Planning & Urban Development Department

Project Name: Hotel Conversion – 119 Exchange Street Project ID: 2012-602
Address: 119 Exchange Street CBL: 032-c-001
Applicant: 119 Development, LLC

February 12, 2013

Project Name:	Hotel Conversion- Former Gannett Building	Project ID:	2012-602
Address:	119 Exchange Street	CBL:	032C001
Applicant:	119 Development, LLC		
Planner:	Shukria Wiar

PRECAST CATCH BASIN ALONG GUTTER LINE DETAIL
N.T.S.

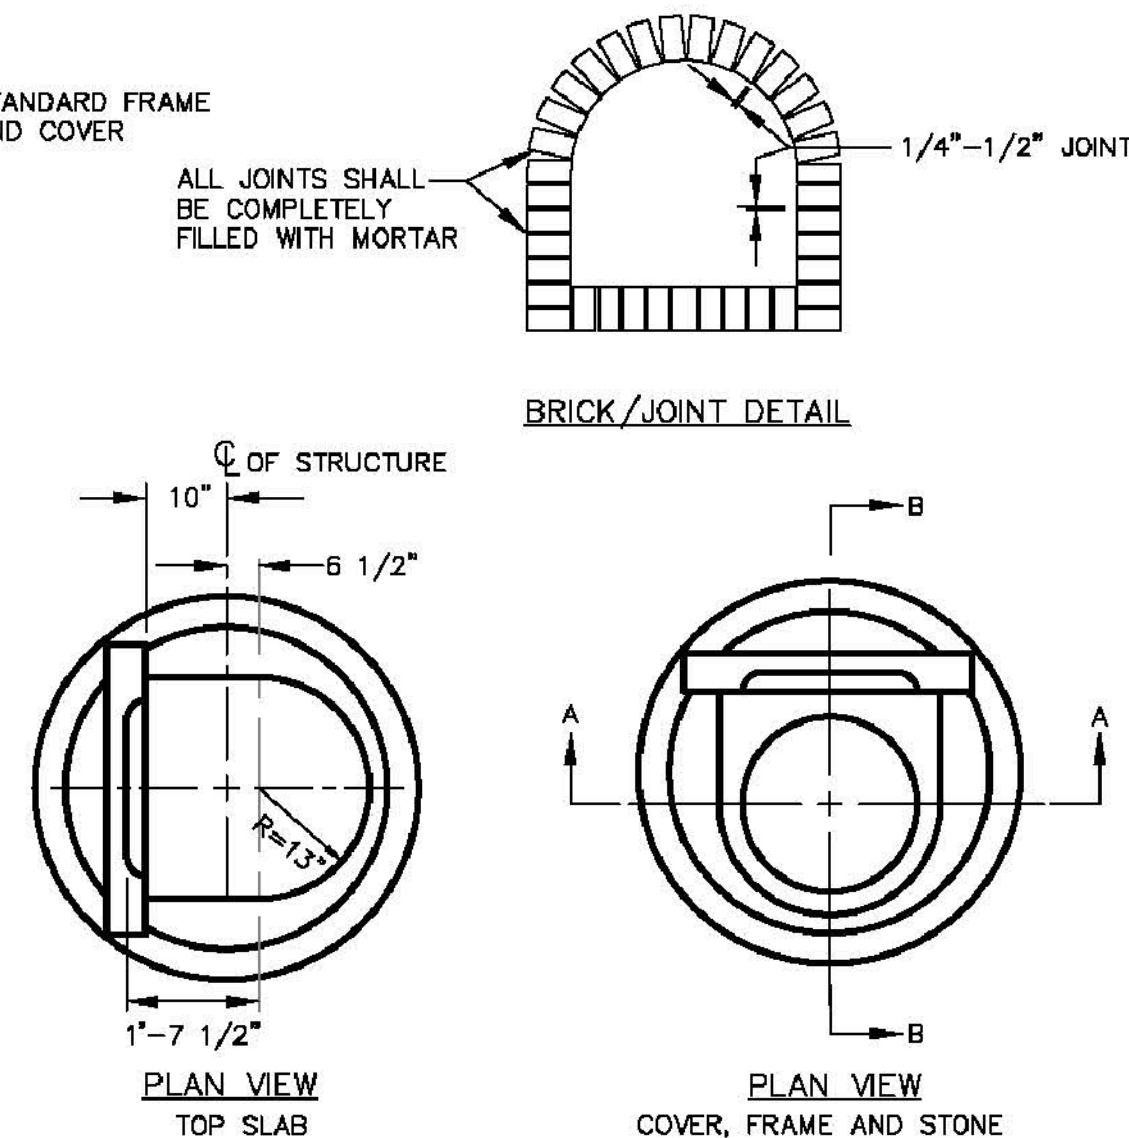
David Senus, Consultant Engineer with Woodard and Curran, has reviewed the site plans and recommends that "the existing catch basin within Federal Street should be replaced, and the new basin should be situated along the gutter line with a standard grate and curb inlet in accordance with the City's standard details".

The existing catch basin within Federal Street shall be replaced, and the new basin shall be situated along the gutter line with a standard grate and curb inlet in accordance with the City's standard details. The final site plan shall be updated to show this change. A note is to be added that all work within the street right of way with meet City of Portland Technical Standards.

TREE PLANTER DETAIL
N.T.S.

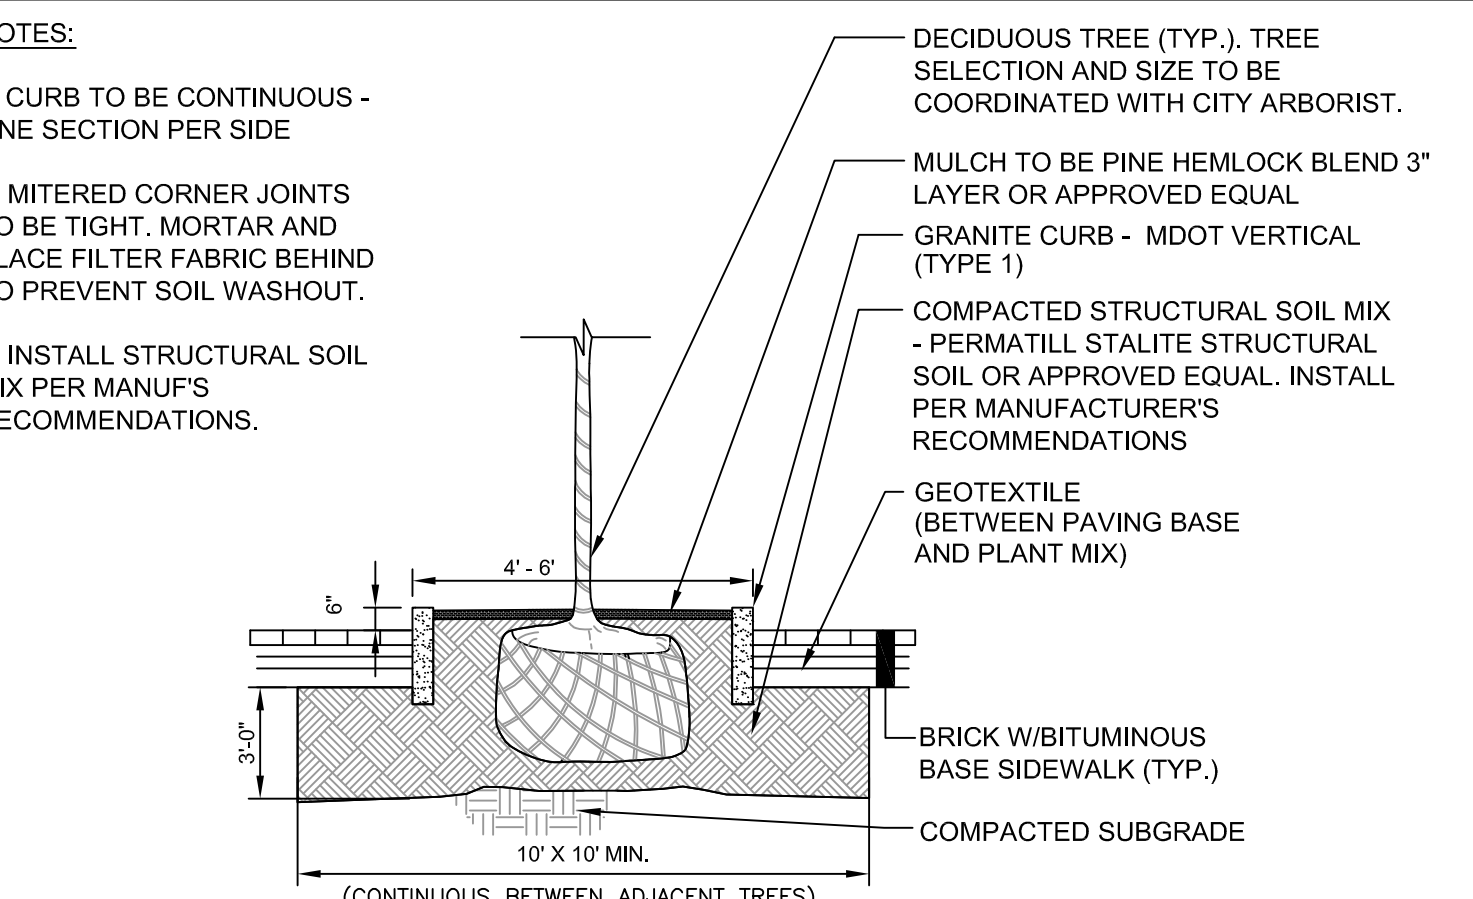
- a. The tree planters at the main entrance on Exchange Street should not be located in the sidewalk and obstruct the primary pedestrian route.
 - b. Based upon the specialty sidewalk material and an underground snow melt system, a maintenance agreement should be executed for the main entrance on Exchange Street such that the applicant is responsible for maintaining the "bump-out" area.

The tree planters at the main entrance on Exchange Street shall not be located in the sidewalk and obstruct the primary pedestrian route.

SIDEWALK RAMP DETECTABLE WARNING PANEL (HISTORIC DISTRICTS AND LANDSCAPES)
N.T.S.

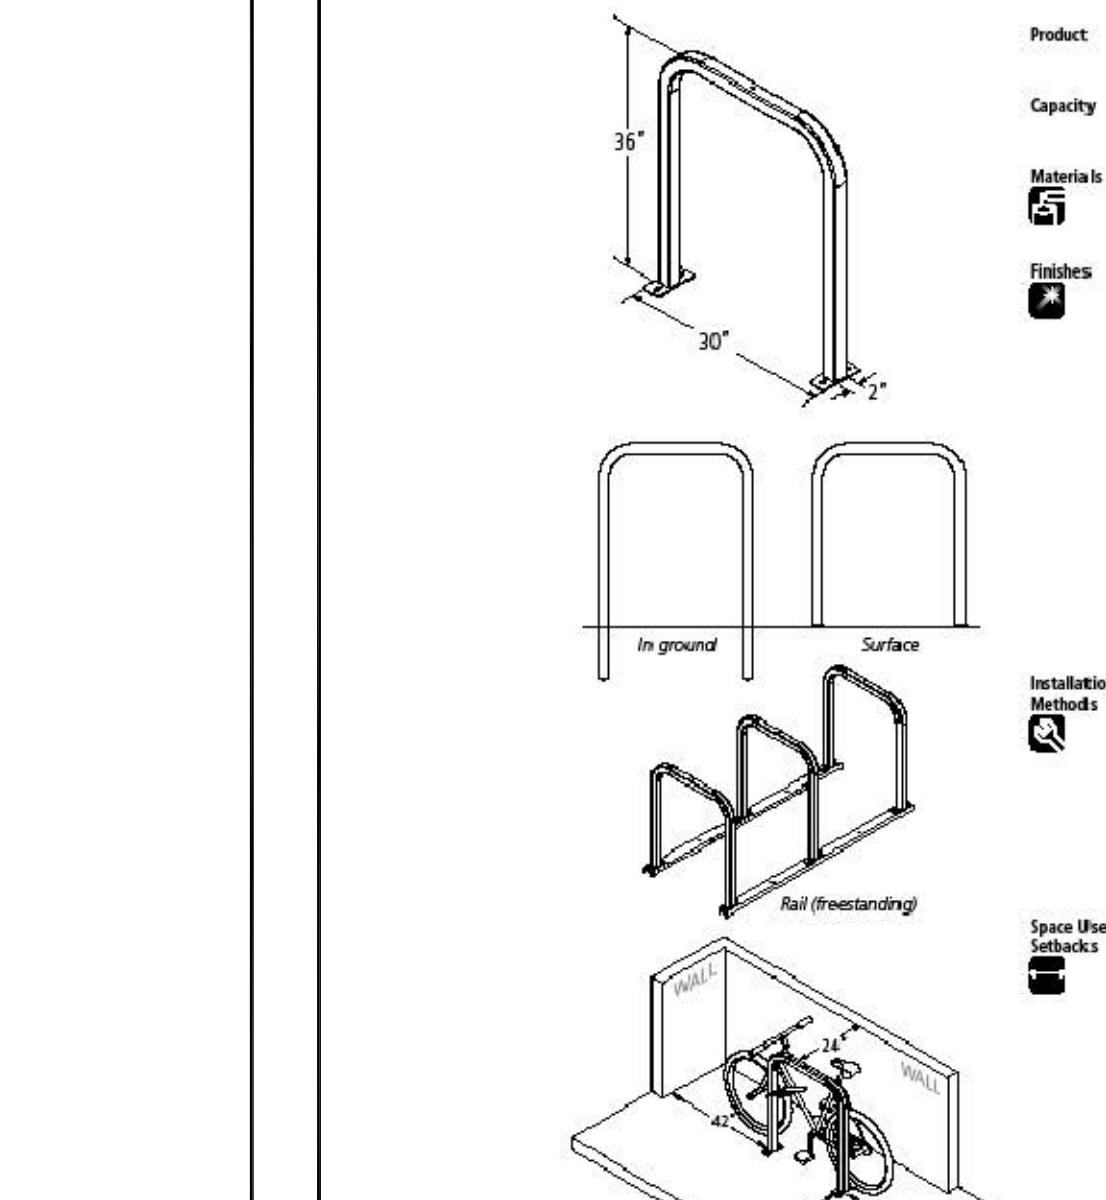
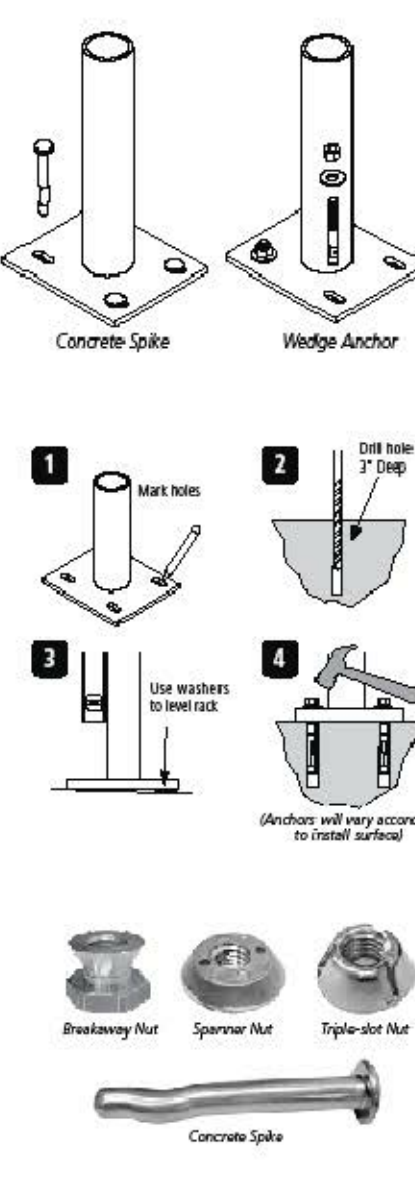
- i. The project will be upgrading sidewalks surrounding the building. Coordination with DPS on appropriate sidewalk ramp design and ADA compliance will need to take place.
Status: Specific sidewalk comments are noted below:

- c. A sidewalk ramp should be constructed on Congress Street at the existing crosswalk at the southwest corner of the Market Street intersection.
 - d. The applicant is proposing the relocation of the existing curbing on Federal Street between Market Street and Exchange Street to provide a wider sidewalk. I find the resultant roadway width of Federal Street to be acceptable. I would note that the travel lane alignment for westbound traffic will require a slight shift by motorists. Based upon low travel speeds and volumes, I expect conditions to operate safely. However, I would suggest that a condition of approval be established that requires conditions to be monitored. If post-improvement conditions indicate a deficiency, the applicant would be responsible for any required pavement marking and/or signage changes to mitigate the identified deficiency.
